East Park Energy Solar Project

DCO Application 010141

Submission by Phil Wayles on the Applicant's A1/B645 Junction Technical Note

Submission by Phil Wayles on the Applicant's Updated Outline Construction Traffic Management Plan (oTCMP)

Figure 2-4 Proposed Site Access (Rev P01)

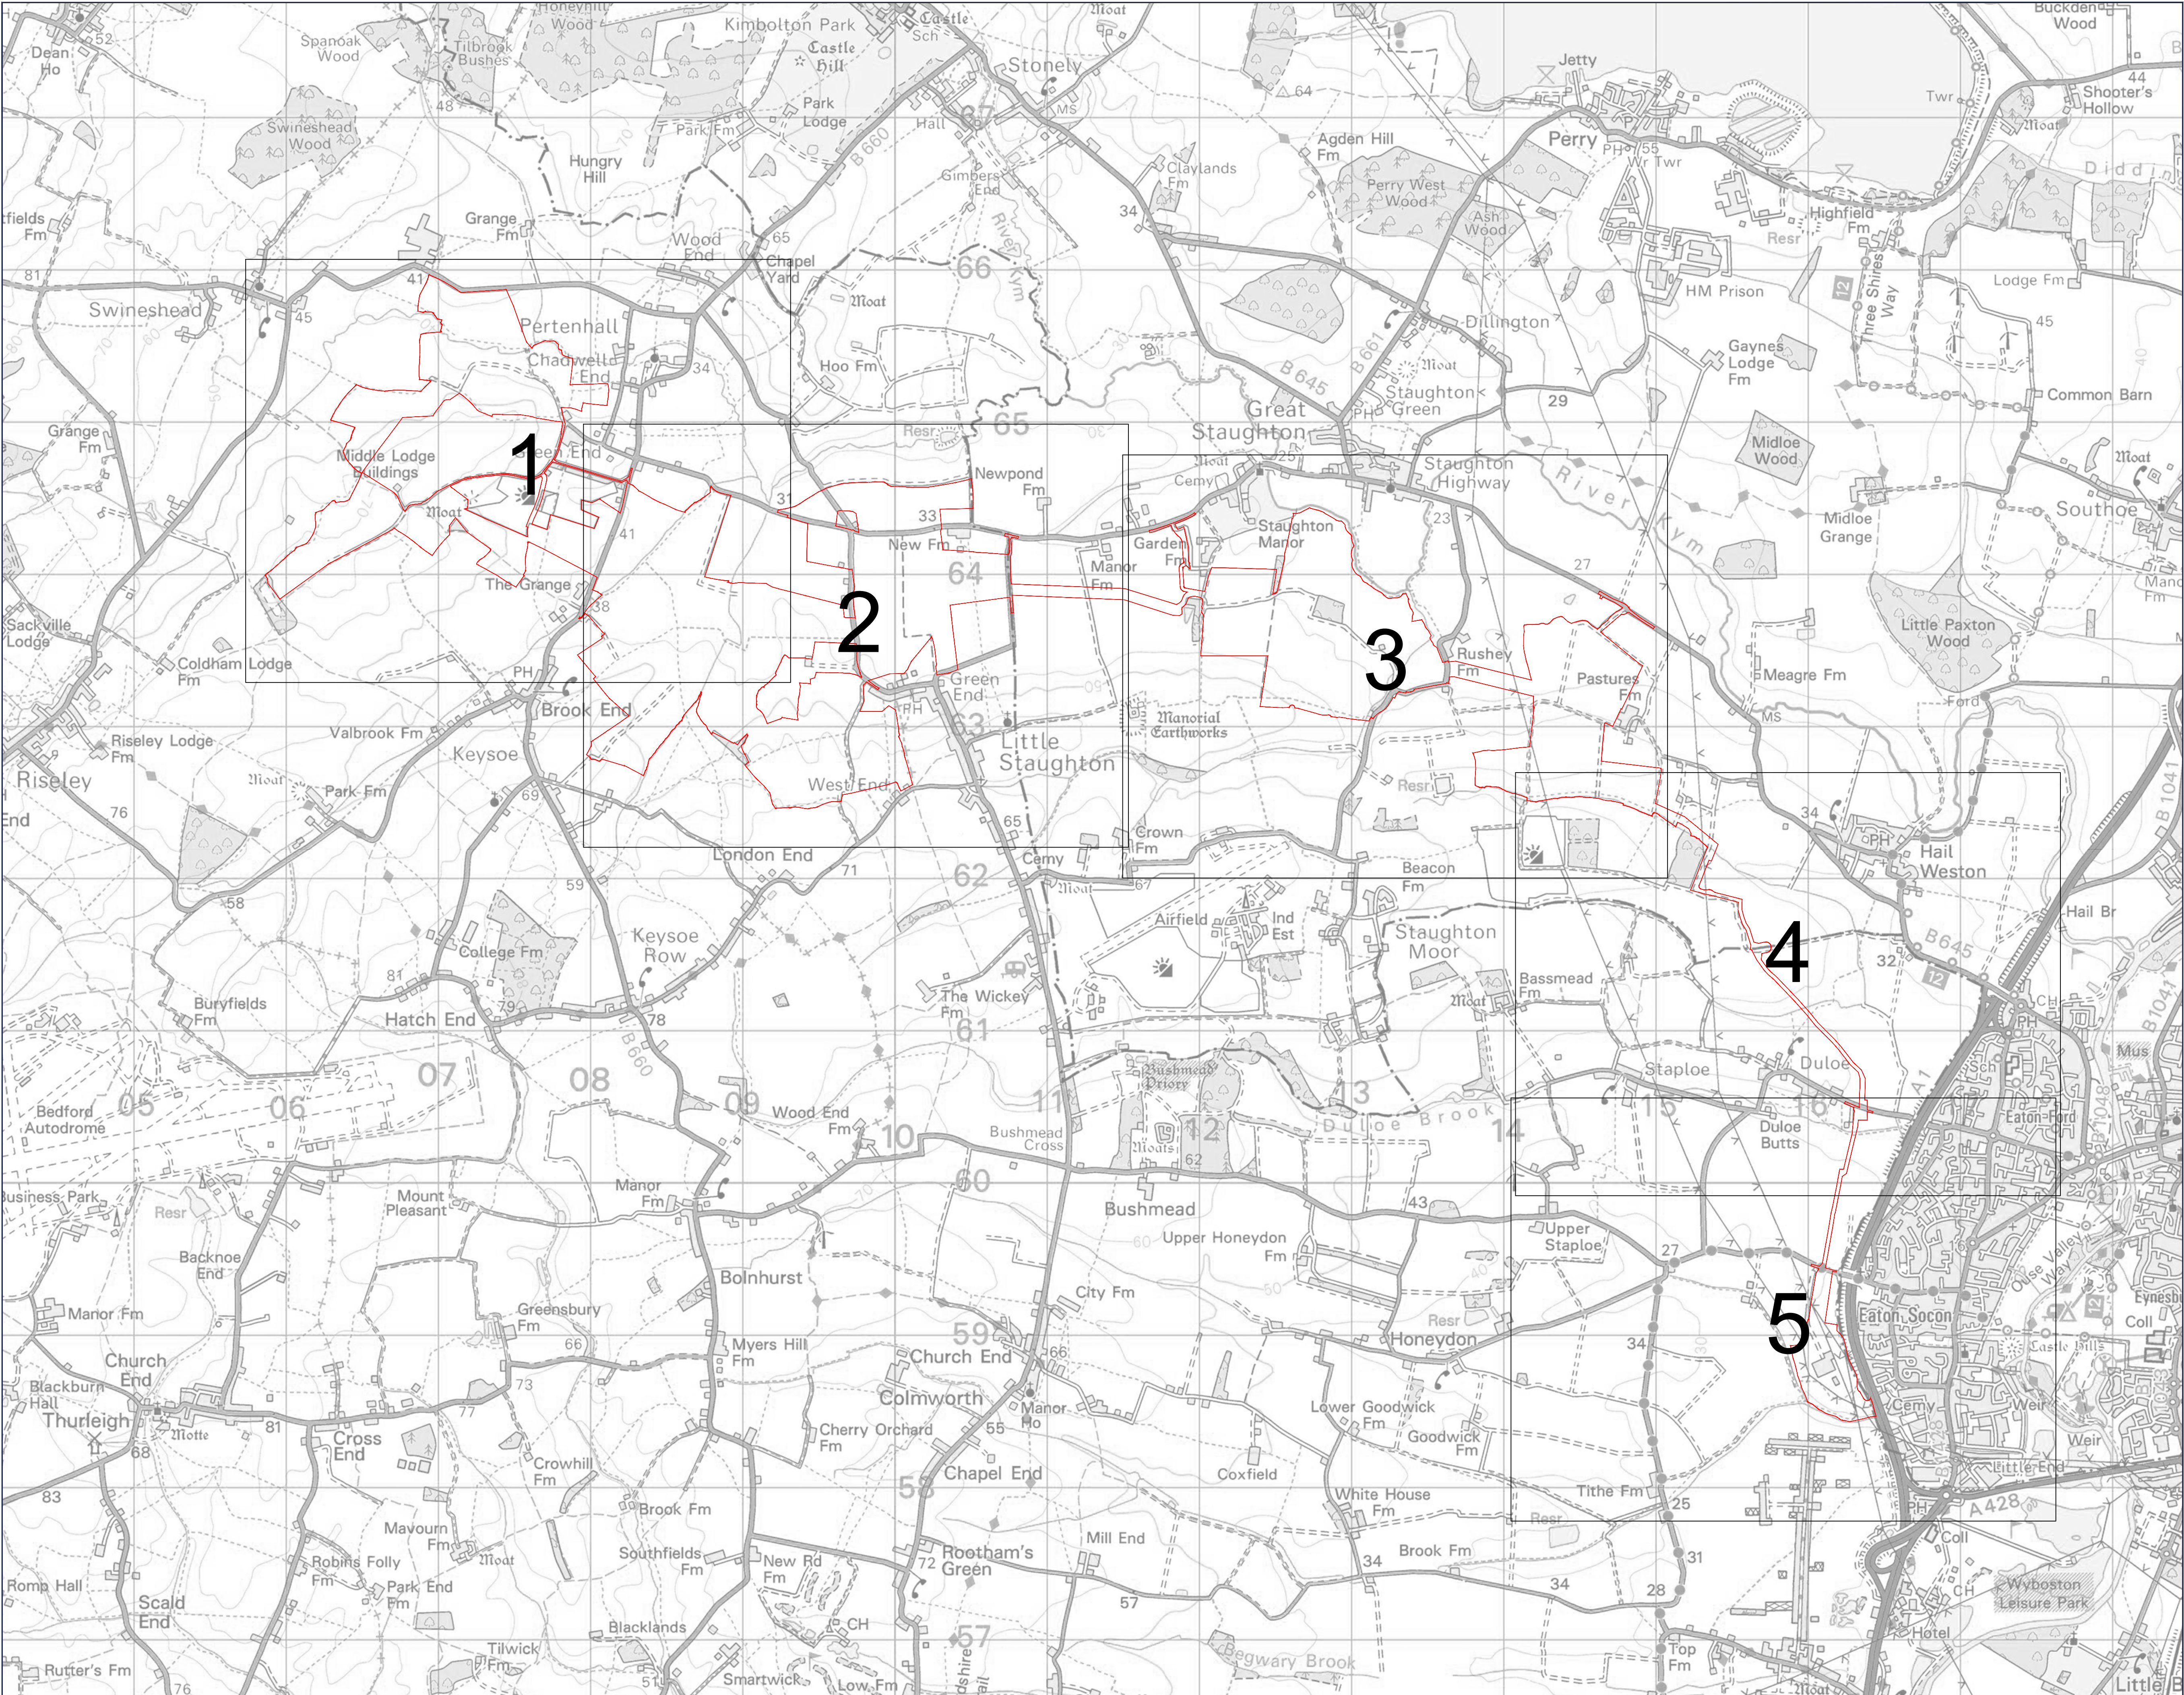
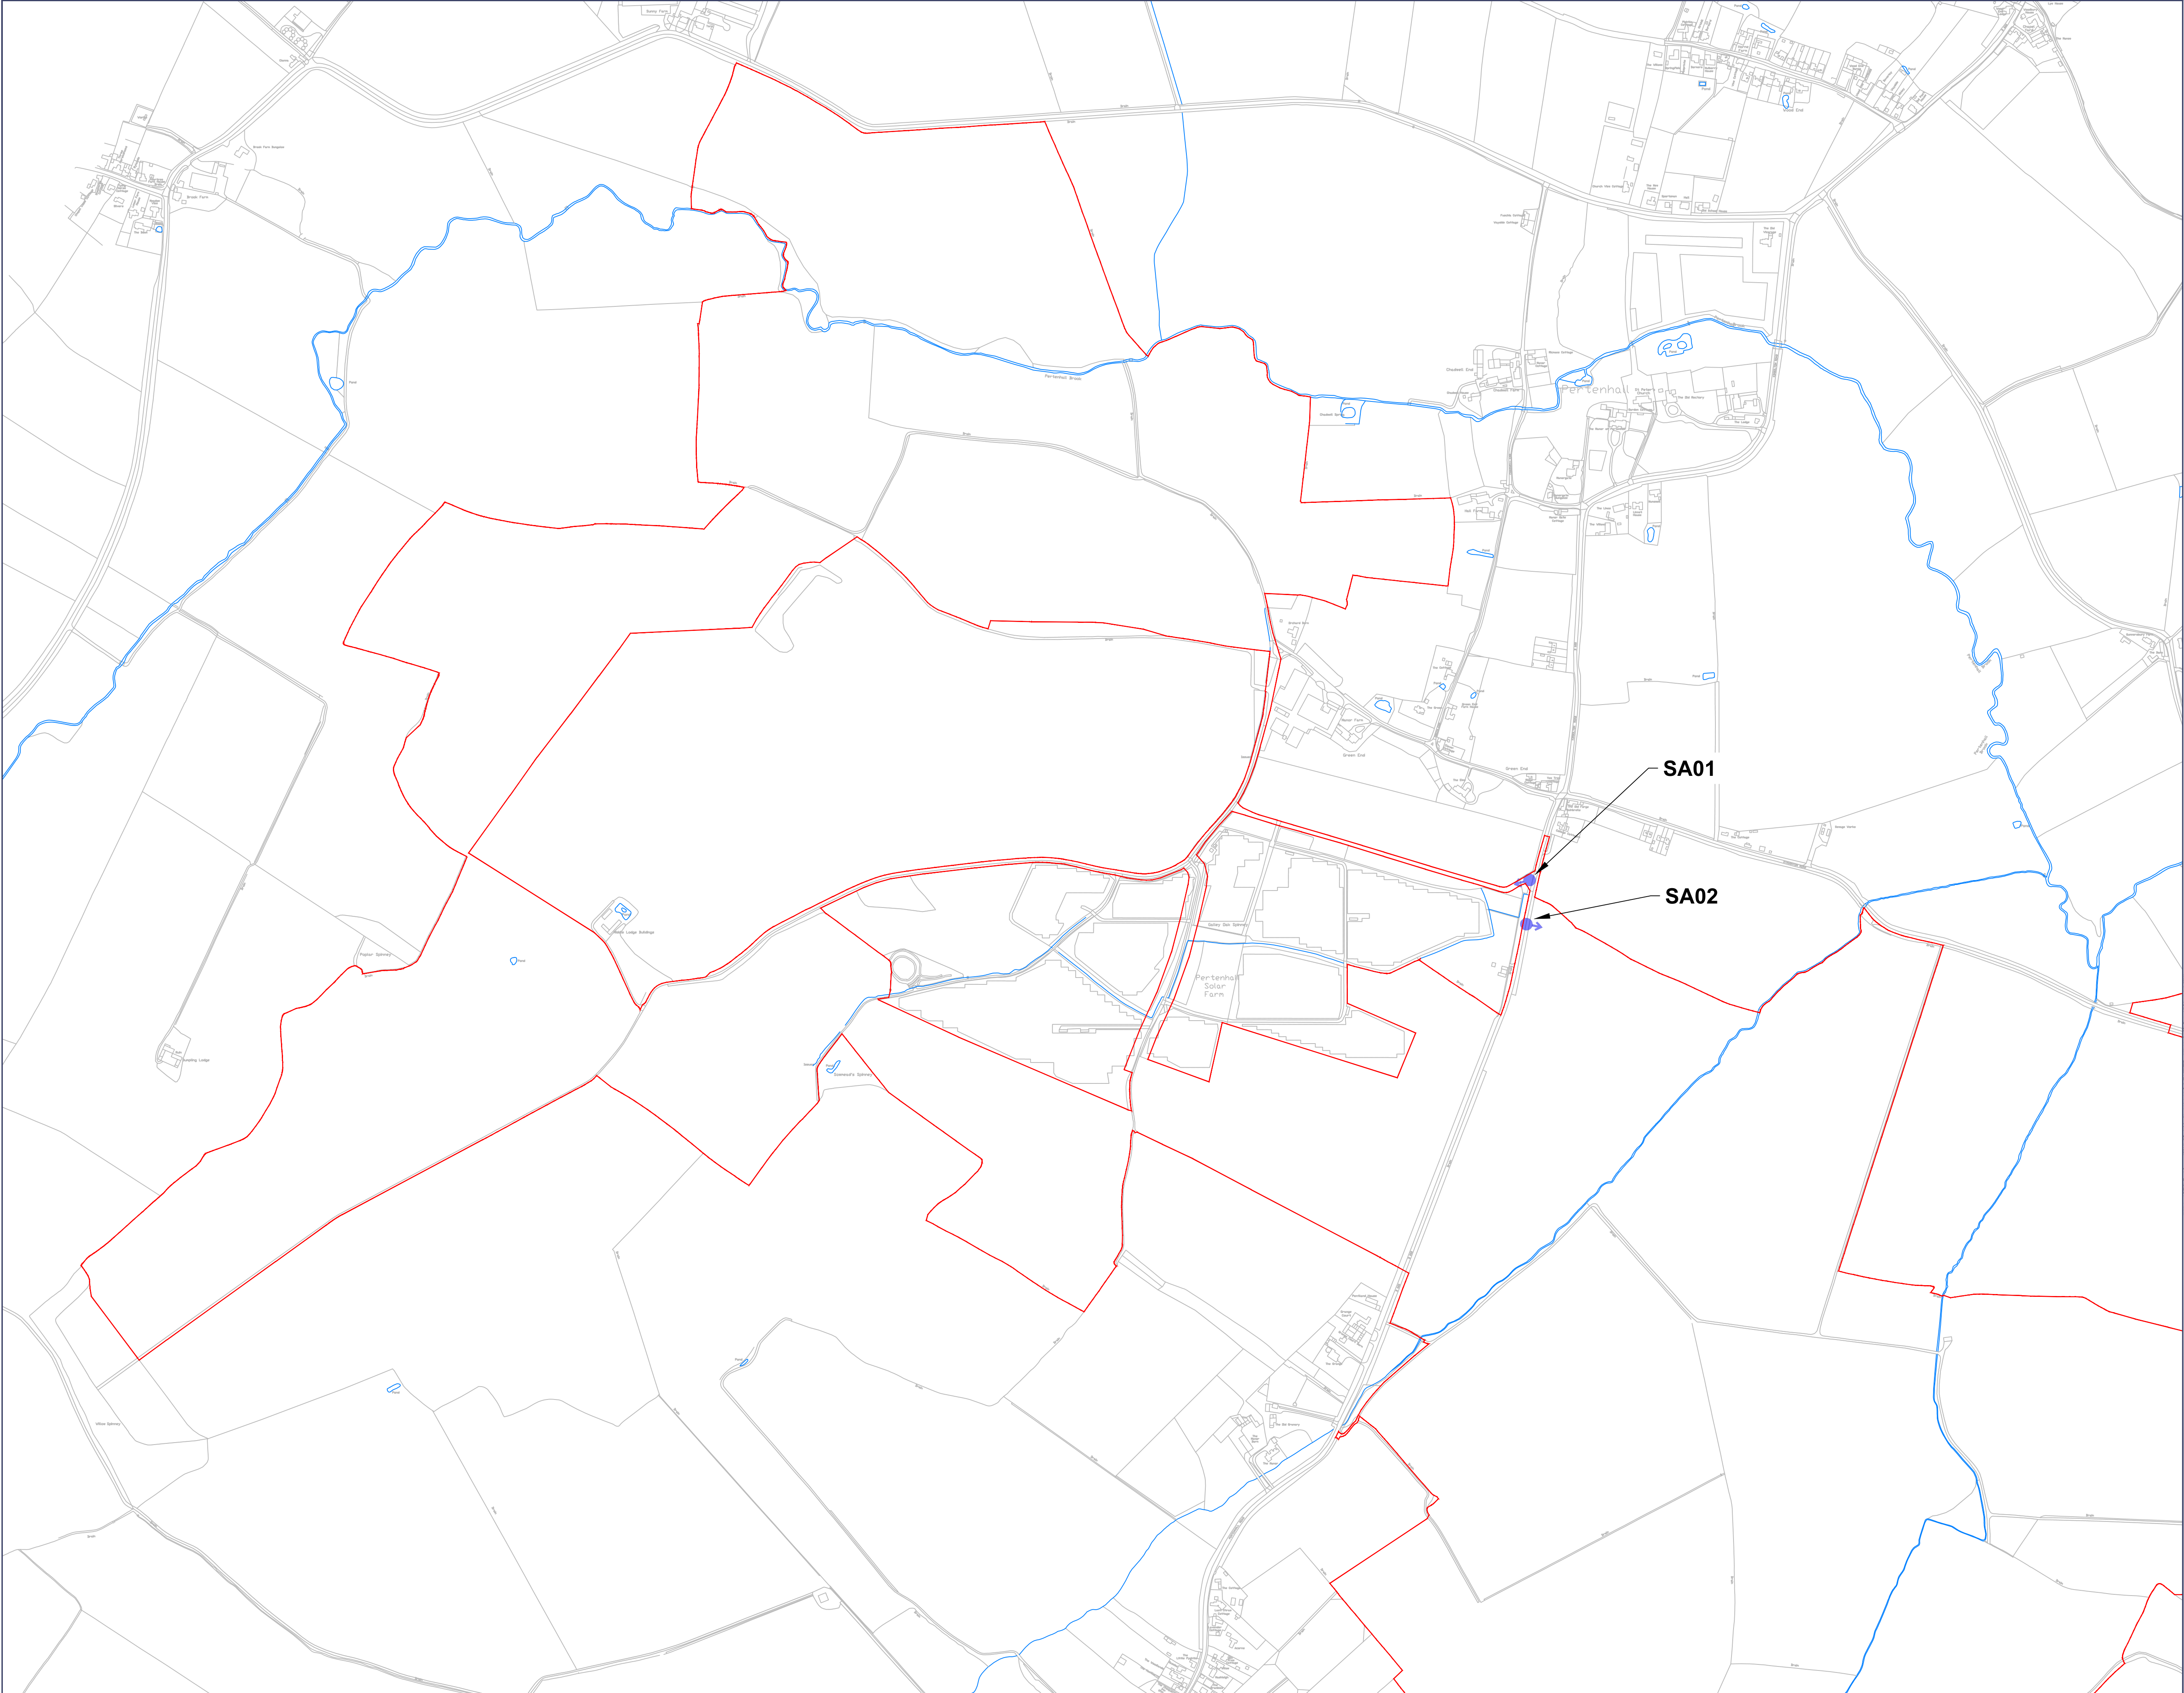
Para 5.1.11 states "*Site B also has a number of site access junctions which require construction traffic to use short sections of the public highway along Great Staughton Road (SA03, SA04, SA05, SA06) and Green End (SA09).*" Also with reference to Para 5.2.1 and 5.2.2, the Applicant's traffic-flow diagrams appear to assign only minimal construction vehicle movements to the SA03–SA06 Great Staughton Road accesses and SA09 at Green End, despite those accesses serving substantial areas of Site B proposed for solar panel development and two of the satellite compounds. The Indicative Site Access Drawings in Appendix D also include swept path tracking diagrams for these accesses. The application does not transparently explain how the

site areas accessed by SA03, SA04, SA06 and SA09 can be constructed with such limited access movements especially as road widening is required at some locations. This creates uncertainty as to whether the traffic assessment materially understates localised construction activity on Great Staughton Road and Green End Road. The satellite compound near Green End should be accessed by an internal haul road, rather than by public highway and site access SA09. This emphasises the oCTMP does not explicitly and clearly set out which existing roads will be used by construction traffic, nor does not show comprehensive details for as requested by the Local highways Authorities and several IPs. A Construction Traffic Permitted Routes / Restricted routes must be prepared for the whole area bounded by the A1, A14, Bedford to the south and B660 / Swineshead Road to the west.

Para 5.1.13 has been updated to “*Minor road widening works will also be required along Spring Hill Road, and potentially Great Staughton Road, to facilitate the two-way movement of HGVs between access SA12 and access SA10 during the construction phase.*” As described at the ISH, this requires HGV construction traffic to travel on sections of Great Staughton Road and Spring Hill Road between these 2 accesses (SA10 and SA12) rather than use an internal haul road between Sites B and C. The change to use a section of the public highway was introduced in the Stat Con documentation, although difficult to interpret. At Non-Stat Con, the Applicant intended to use the internal cabling corridor for temporary construction access (haul road). It is illogical and inappropriate to use and widen the existing public highway when a perfectly sensible alternative exists using an internal haul road to be built along the cable route between Sites B and C as shown on Figure 15 - Proposed Construction Access Strategy in Appendix C (see extract below). This plan indicates there is a temporary haul road along the cabling corridor route which is due to be removed post- construction. Mandating use of this section of temporary haul road would improve safety and limit damage to the existing roads by keeping large and heavy site vehicles off the public highway. Furthermore, there would be further disruption to traffic during the construction of the widening works, and this section of the public highway would be also used during the operational replacement works and decommissioning works. This disruption also applies to the road widening works required at several of the new proposed site accesses to accommodate the HGV swept path tracking shown on the Indicative Site Access Drawings.

Appendix D: Indicative Site Access Arrangement Drawings has been added. These show geometric design parameters for each access and crossing. Visibility splays and swept path tracking for rigid and articulated HGVs. The access / crossing designs, existing carriageway widths and fencelines are based on OS Mastermap data. The design should be based on topographical survey data, so the design details are based on accurate road location / width, roadside drainage features, road furniture such as traffic signs, trees and hedgerow position and width. These drawings therefore do not accurately show the extent of works and greater lengths of road widening and hedgerow trimming/removal to achieve the necessary visibility splays. The latter point was raised by the local highway authorities such as BBC in their LIR at Section 11.17 a) iii. The extent of hedgerow removal is already understated in the environmental assessment and impacts of the BNG calculation. Additionally, and as set out above, Sections 5.4.2 and 5.4.3 say the visibility splays at each proposed access are Design Manual for Roads and Bridges (DMRB) compliant. This requirement was requested by BBC at Section 11.17 (Matter 50) and this section highlighted that DMRB visibility splay standards were more onerous than those using Manual for Streets (MfS) criteria. However, some plans in Appendix D still show visibility splays including for Accesses SA14, SA15, SA17, SA18, SA19 and SA20 designed to MfS standards. This potentially makes the access less safe and would require greater lengths of hedgerow removal or trimming.

The very fact that some roads need widening (including to construct several site accesses) proves this local road network is unsuitable for the intended construction vehicles. Also, details are not provided for the traffic management arrangements and traffic diversion routes during construction (including to build the accesses and widen roads).
